Project:	Park Danforth
Location:	Portland, ME
Becker Job No:	3422

OBSERVATION REPORT

Cast in Place Concrete

Date:	06-30-16
Time:	10:00 AM
Temp:	80° F
Weather:	Sunny

**S1.1B**

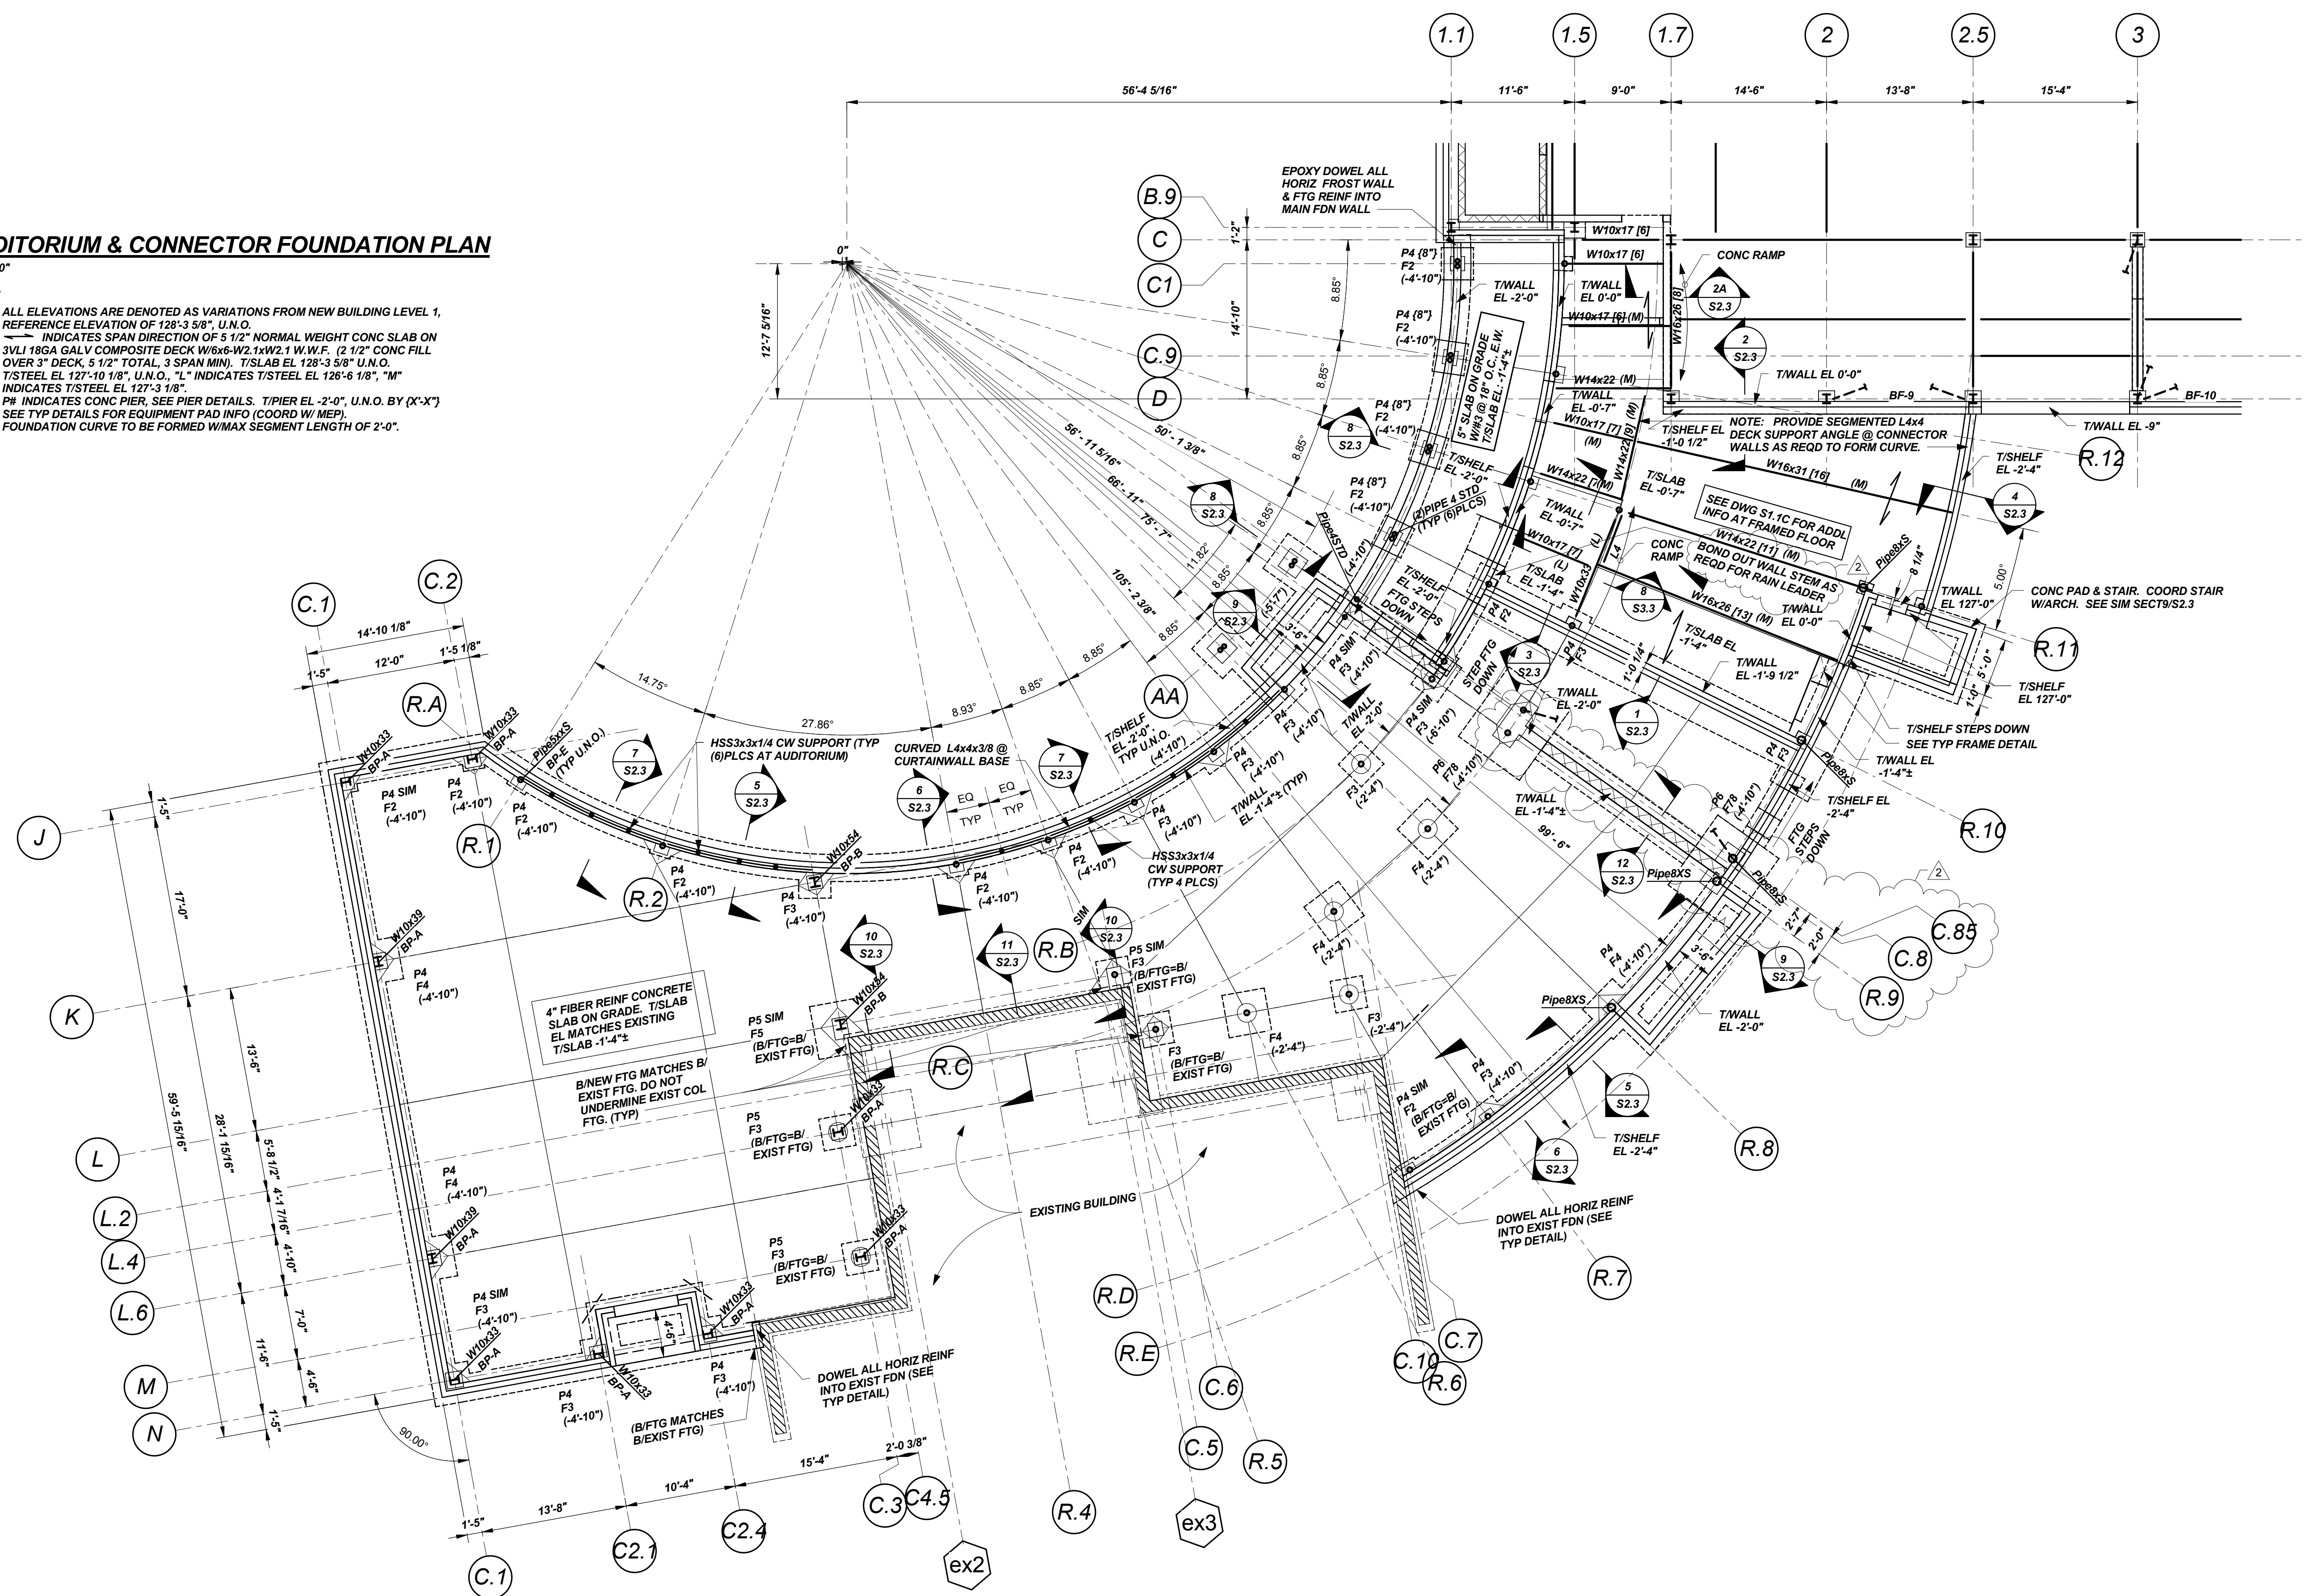
Connector foundation wall footings around the auditorium, on R.A line from R.1-R.5, on R.D line from C.7-R.10, on R.9/C.85 from R.C-R.D and isolated footings C.3/L.4, C4.5/L, C.5/L, C.6/L.2.

While on site I reviewed the new isolated footings located against the existing building with Chris from Giles. For conditions in which a new footing overlaps the existing foundation the top of footing shall match the bottom of existing footing. The soil shall be removed with hand tools under the existing footing in order to accommodate the new footing (see section 10/S2.3). Where the isolated footings do not interfere with the existing foundation the bottom of new footings shall match the bottom of existing footing.

At footing C.5/L the footing overlapped slightly (approximately 6") with the existing. At this location it is acceptable to drill and epoxy footing reinforcement into the exiting foundation or shift the footing to align with the exterior face.

At footing C.6/L.2 the corner of the existing footing was into the new footing. At this location it is acceptable to drill and epoxy footing reinforcement into the exiting foundation.

At R.D/C.7 the new pier footing was into the existing foundation. Giles was able to install 5 pier dowels and undermine the existing footing to install the new footing. The last pier dowel shall be post installed into the existing footing.

At C.1 line between K and L there was a pipe through the new footing. I discussed with Kemp from PC and Chris that the footing should step down at this location so the pipe could pass through the wall and not the footing (reference S0.0 and typical detail on S2.1).
